Planning Services  
Department of Planning and Environment  
GPO Box 39  
Sydney NSW 2001

**Re: Re: Objection Submission –State Significant Development Application SSD 9741 Lane Cove West Data Centre**

13 May 2019

Drawing Title
VISUAL IMPACT VIEW POINT LOCATION

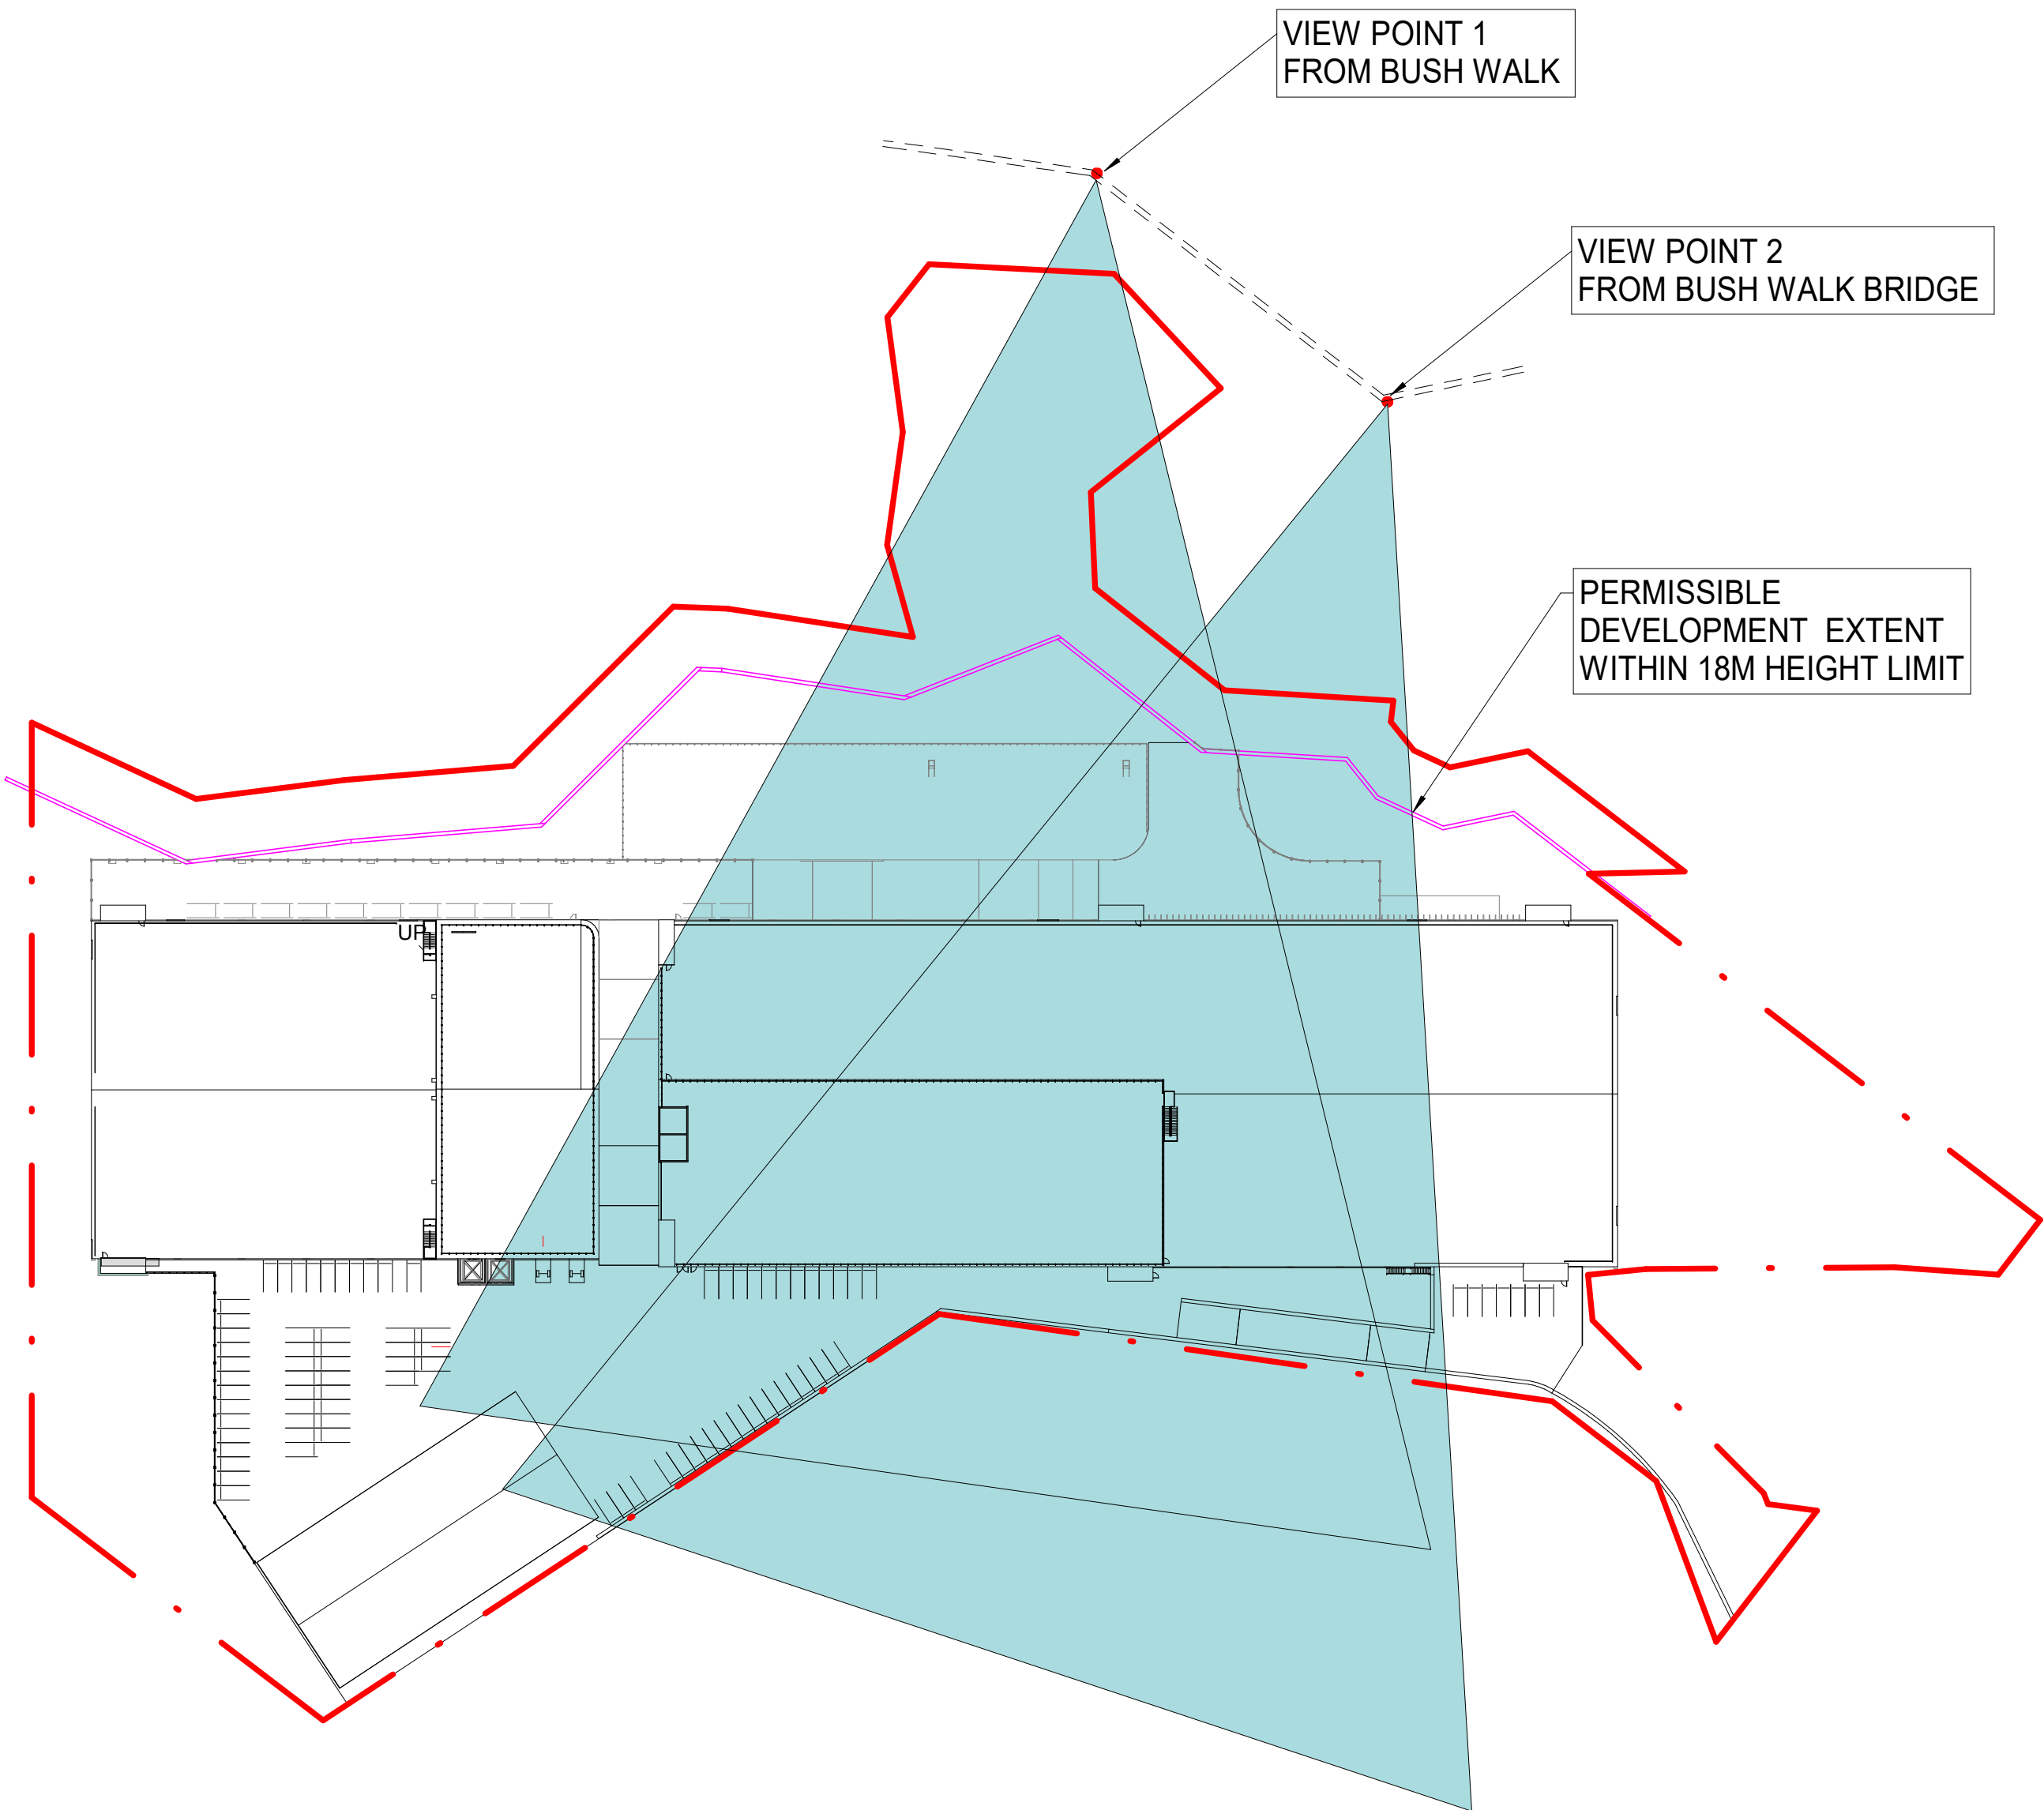
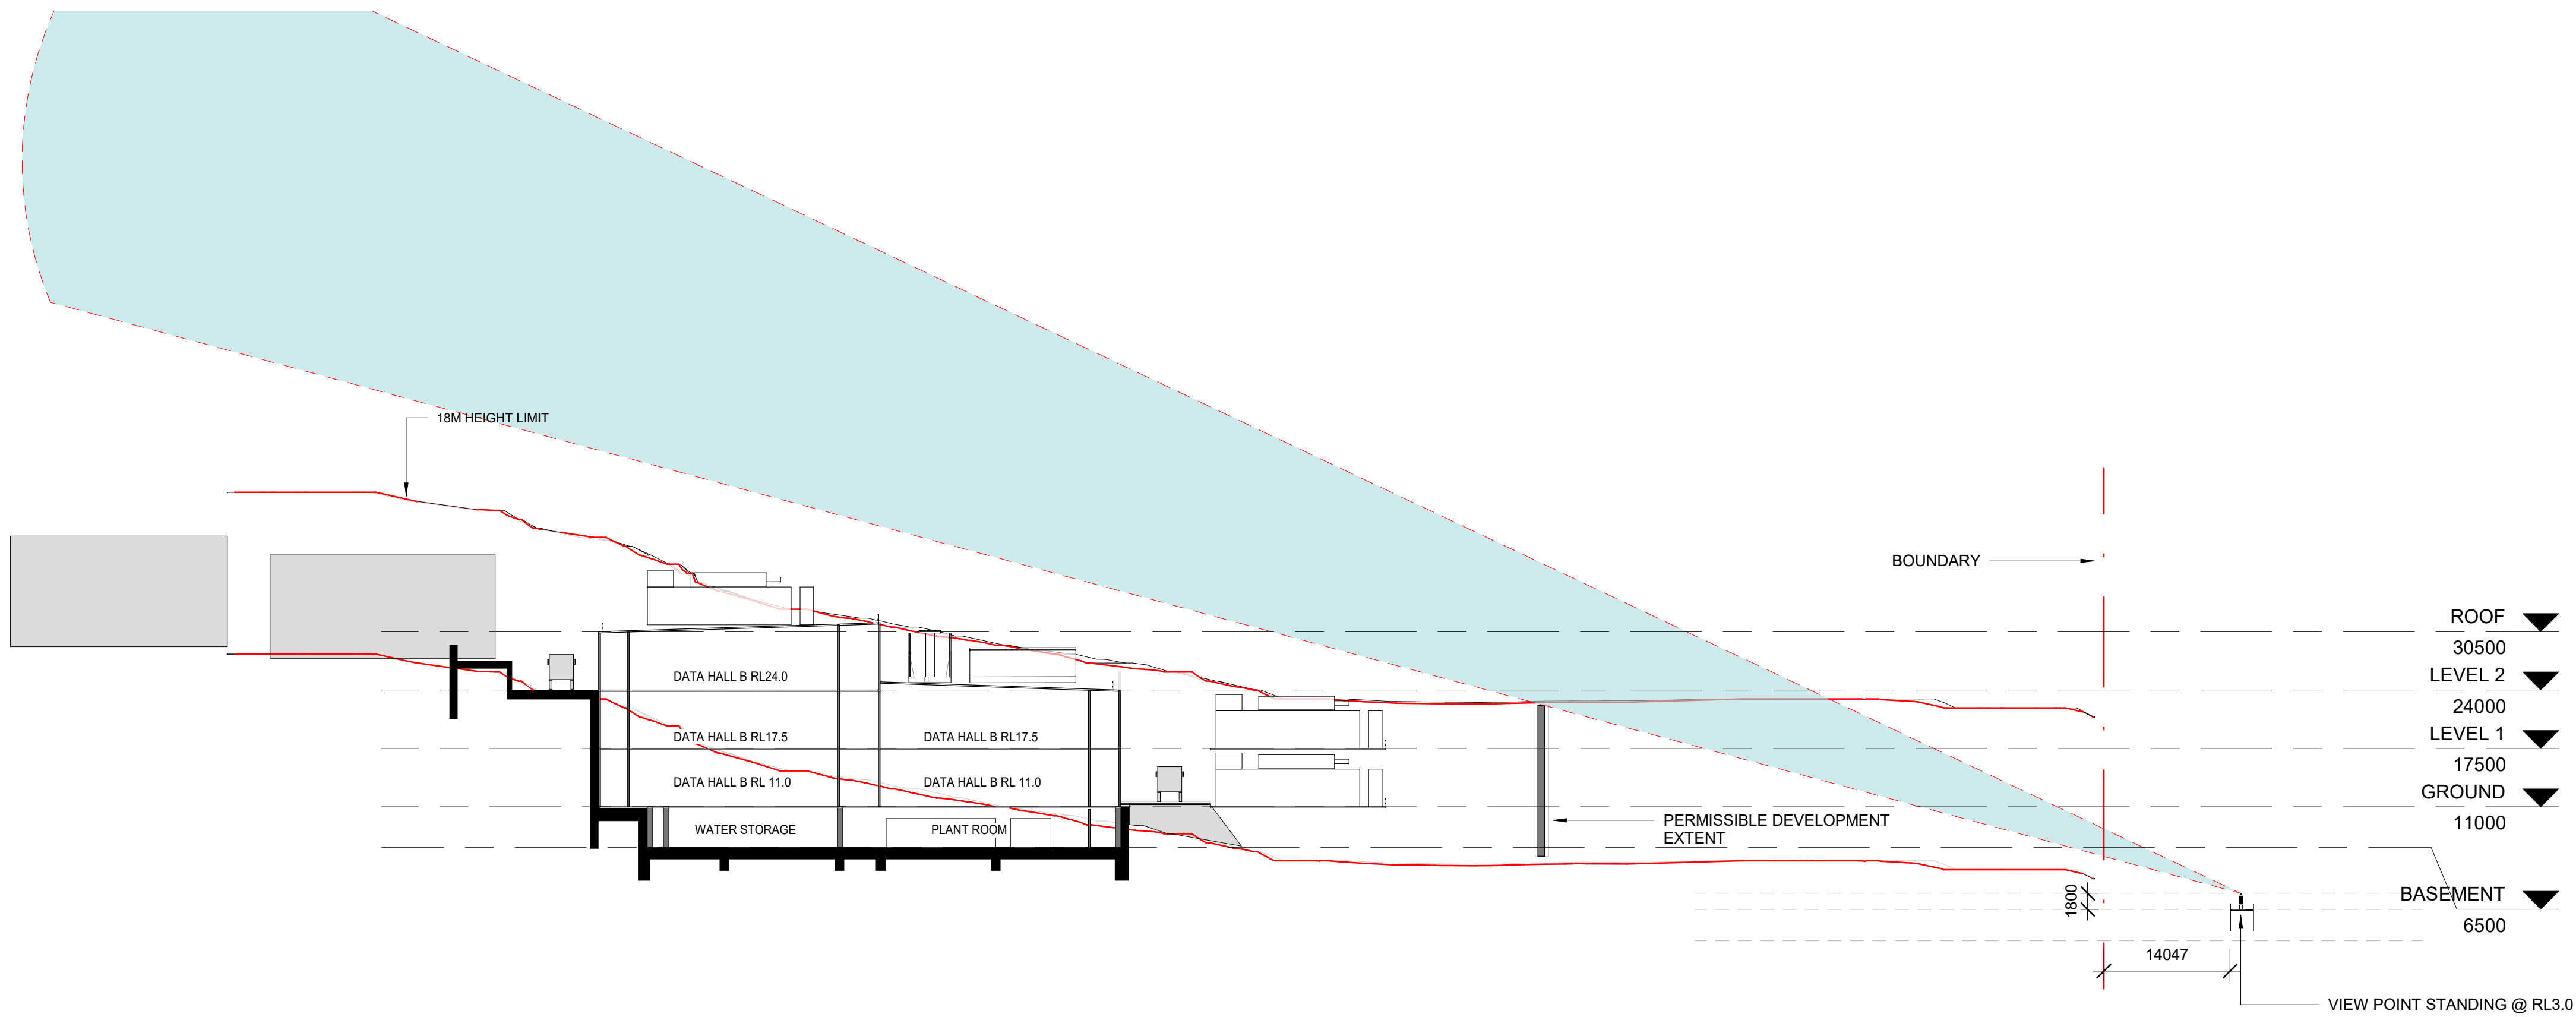
6. **Objection:- Visual Impact** The Visual Impact study is not well-presented for viewer understanding. Clearly a rendered model of the proposal has been worked up, yet no effort has been made to insert different views of this model into photomontages. Photos should be taken using a focal length of 55 mm lens which would much more accurately illustrate the real human viewer's vision, and the models inserted at matching focal length. It is considered that the visual impact of the proposal is highly intrusive. The architectural drawings analysing visual impact have used a trick of implying that the permissible 18m high building extent could be much closer to the bushwalker and hence have a much more intrusive impact. But the reality is, this is not what can be achieved because of required buffers, setbacks, bushfire roads, contaminated areas, and so on. There is a massive long bunker wall facing the bushwalker, relieved only by different coloured slabs of tilt-up concrete or similar. Other than different colours, and some vertical sticks, there is no attempt to soften the rigid parapet line of the rooftop, or create any lacey effects to screen the battle canon-like rooftop plant design. The proposal should be more sympathetic in its position of transition between industrial buildings and the river banks and surrounds. In addition, the elevated columns supporting the driveways are of ugly.
